Arun District Council
Civic Centre
Maltravers Road
LITTLEHAMPTON
BN17 5LF

11th March 2022

**Land South of Summer Lane, Pagham
P/153/21/RES and P/167/21/RES**

DRAWING NUMBER: L01

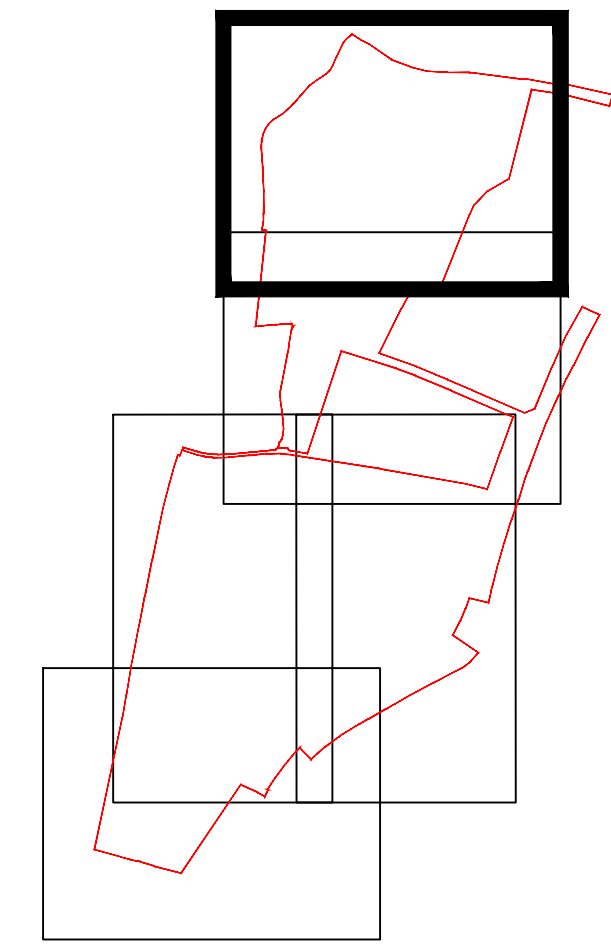
- There is extremely limited green infrastructure or landscaping provided as part of the development. When looking at drawing no. L01 Rev A it is apparent how little landscaping is provided within the street scene. Often the areas of landscaping are awkward in size sitting between or around parking spaces, it is unclear how these spaces are intended to be used or what function they serve in the wider development.
